# ***City of Albuquerque***

**Re: Ventana Ranch Tract HA, Grading and Drainage Plan  
Engineer's Stamp dated 2-17-04 (B10/D8)**

Drainage and  
Grading Plan

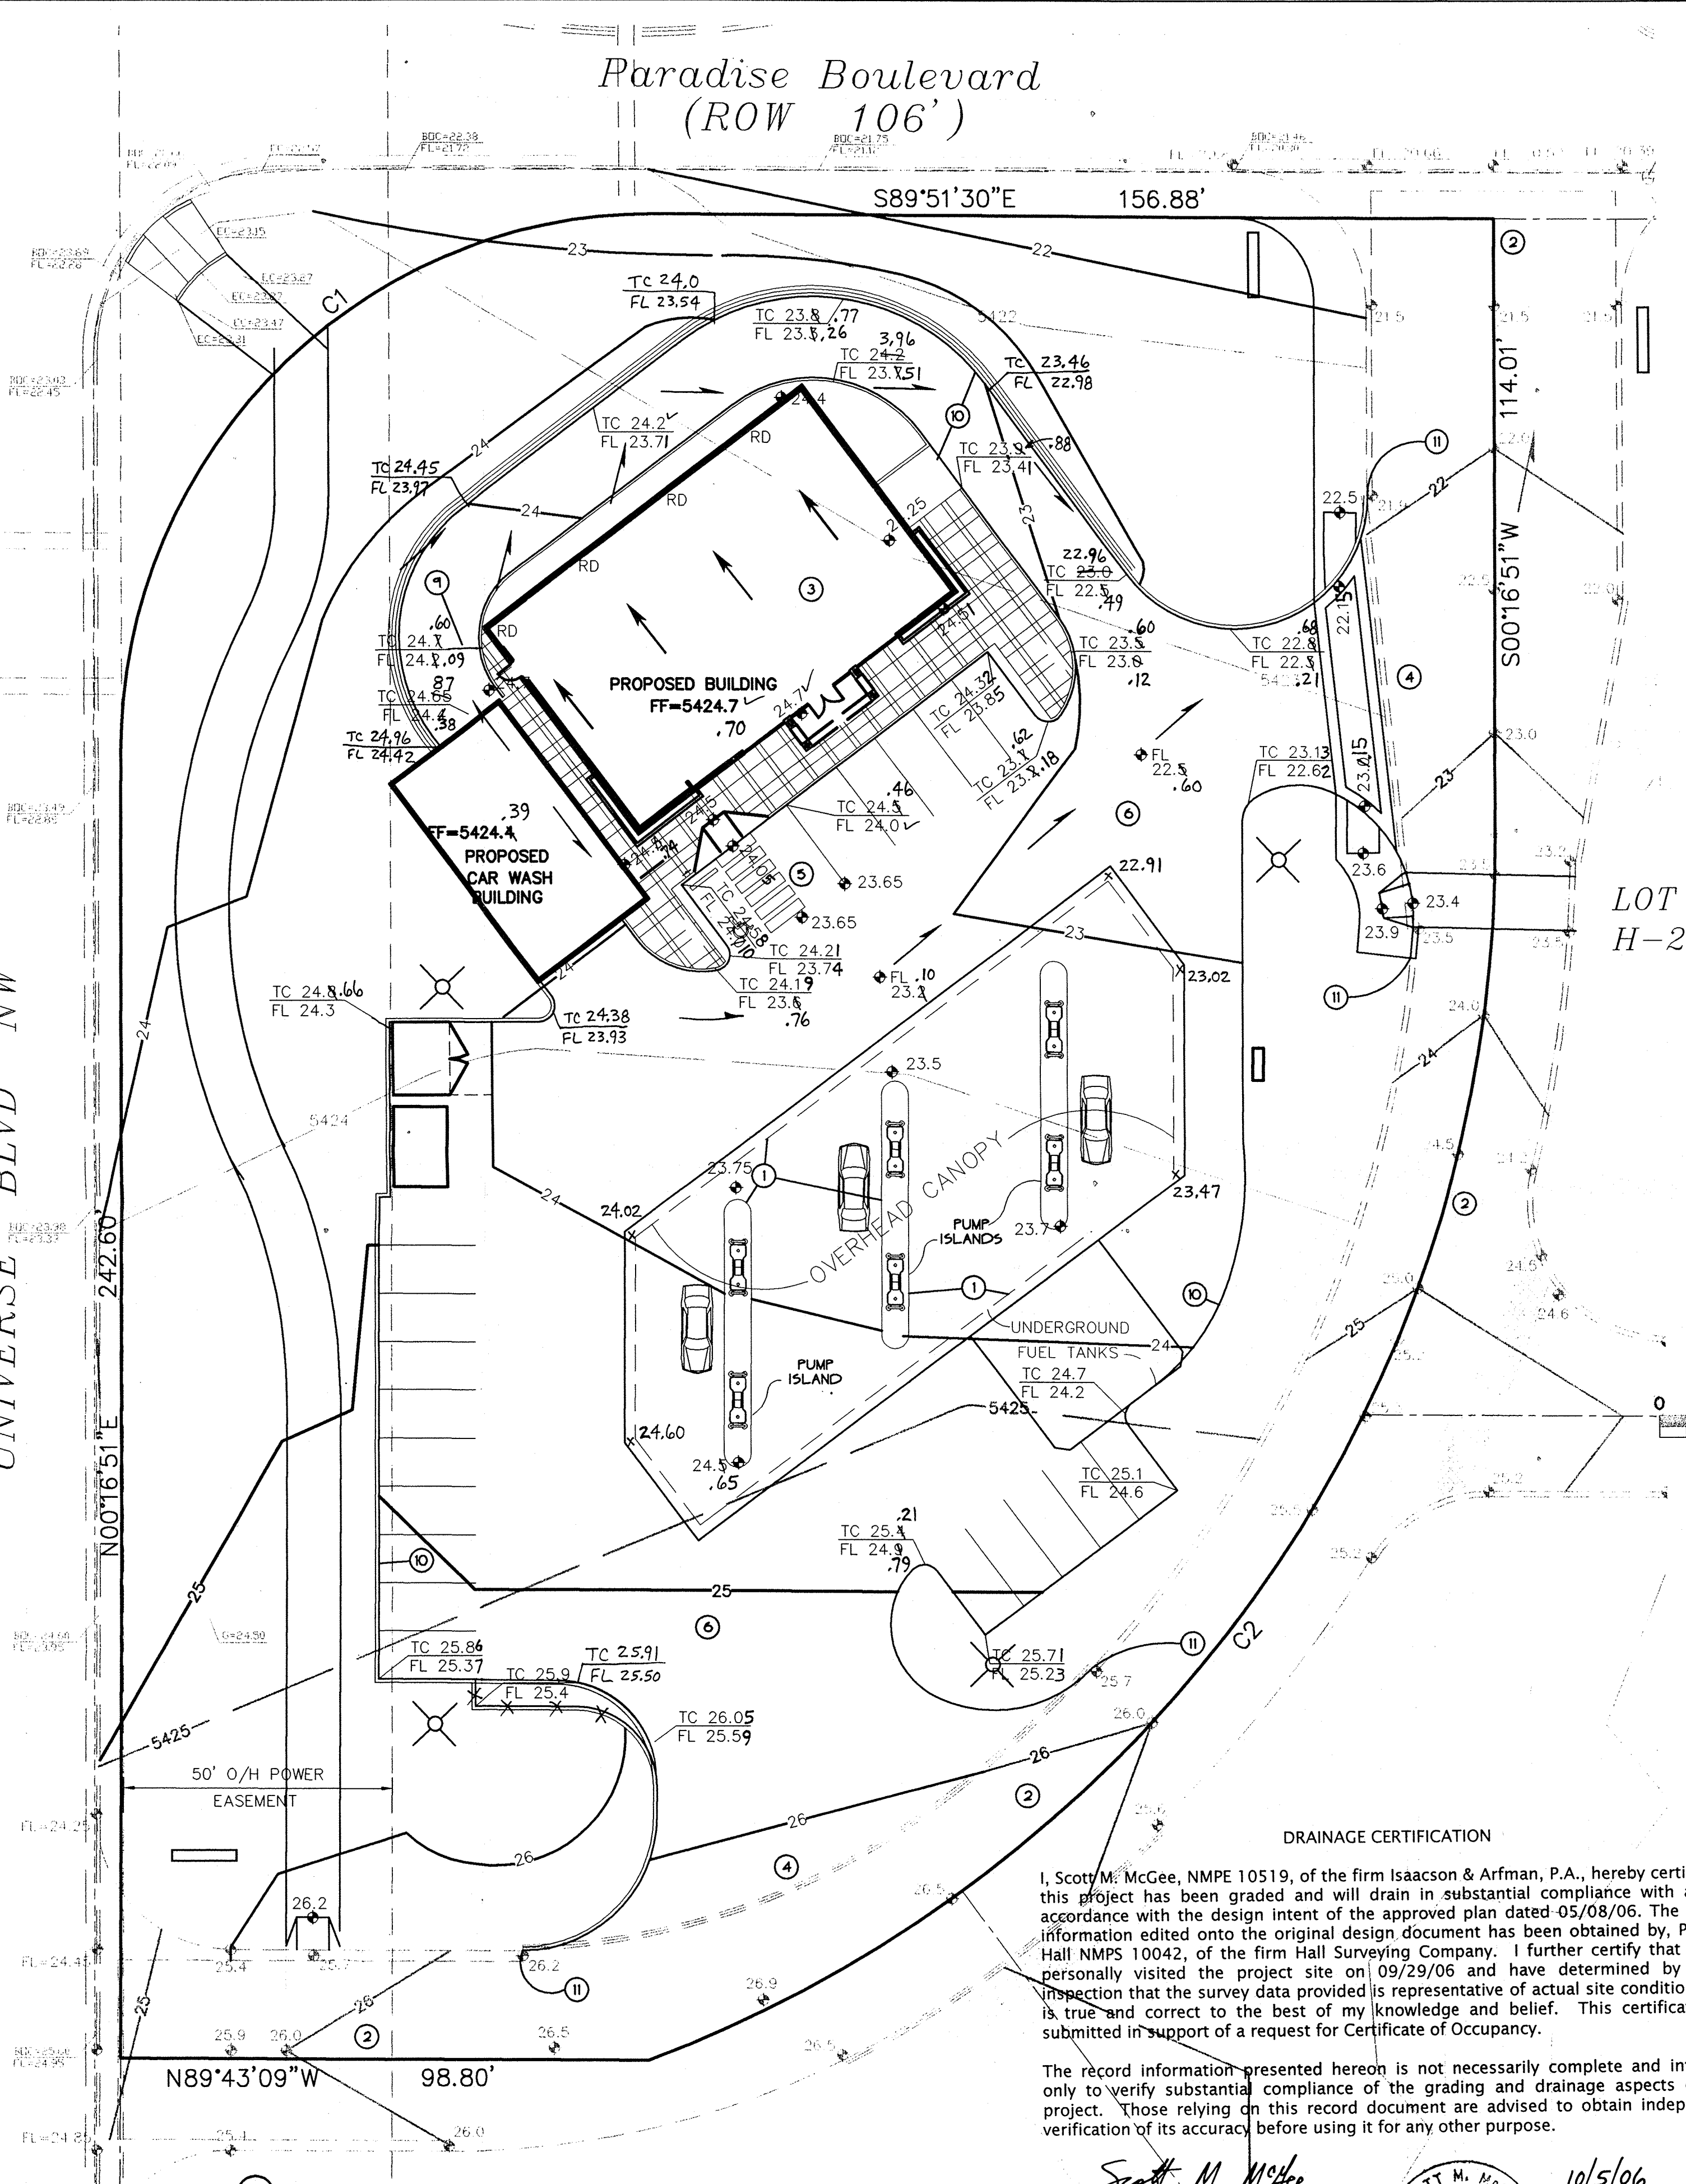
1. How does the flow reach area drain number 2?
2. Provide details of the water harvesting area, such as depth and dimensions.
3. A manhole is required for the tie in to the existing storm drain. Please provide build notes to this effect.
